6 July, 2020

Shaun Williams
Industry Assessments
Department of Planning, Industry and Environment
Locked Bag 5022
PARRAMATTA NSW 2124

**RE: MODIFICATION NO. 18 (MOD 18) – HAND SANITISER ALCOHOL PRODUCTION
SHOALHAVEN STARCHES EXPANSION PROJECT (MP_06-0228)**

Figure 5 – Hand Sanitiser Process Schematic

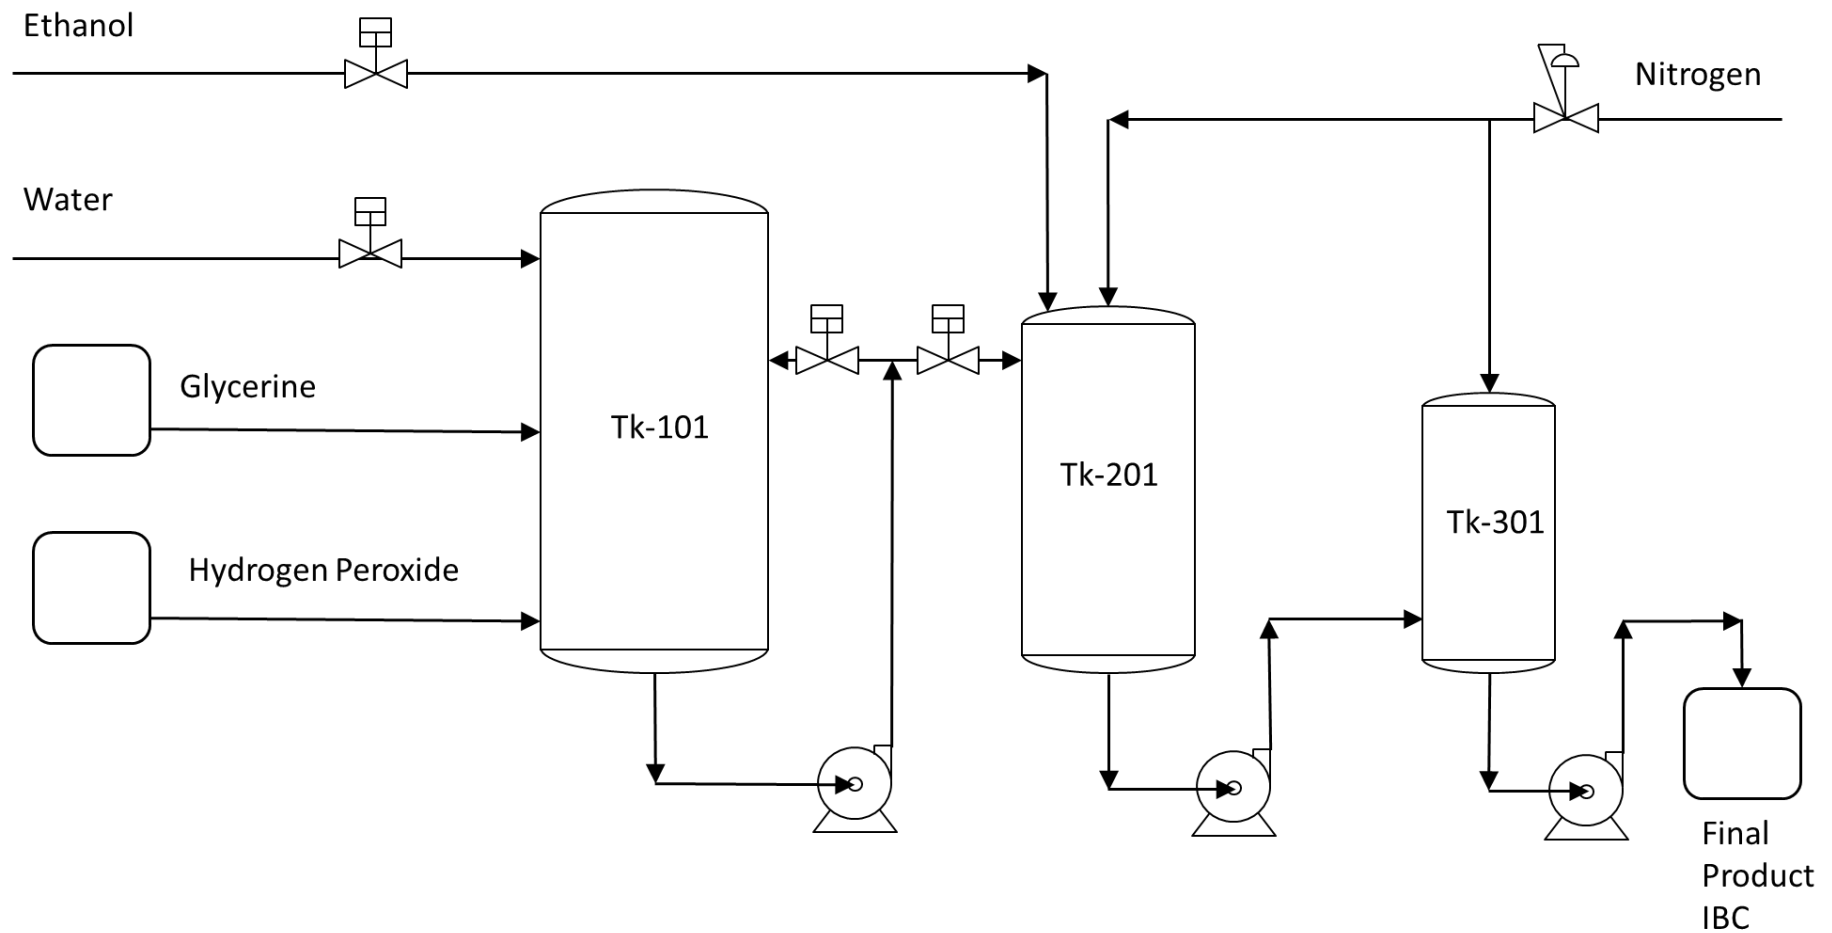
1. *It is noted that SEE only briefly describes the hand sanitiser will be manufactured based on the ethanol produced on site and mixed with additive. However, the specific details are not provided. Please provide details of the following:*

- a. *blending process, location and associated safeguards*
 - b. *types of additive and associated storage quantity, location and DG class.*
 - c. *location of decanting and associated safeguards of decanting process*

Also attached to this submission is a revised Preliminary Hazard Analysis (PHA) prepared by Pinnacle Risk Management. Section 3.3 of the revised PHA includes discussion on the hand sanitiser production process, as requested by the matters raised by points 1 (a – c) of the Department's email.
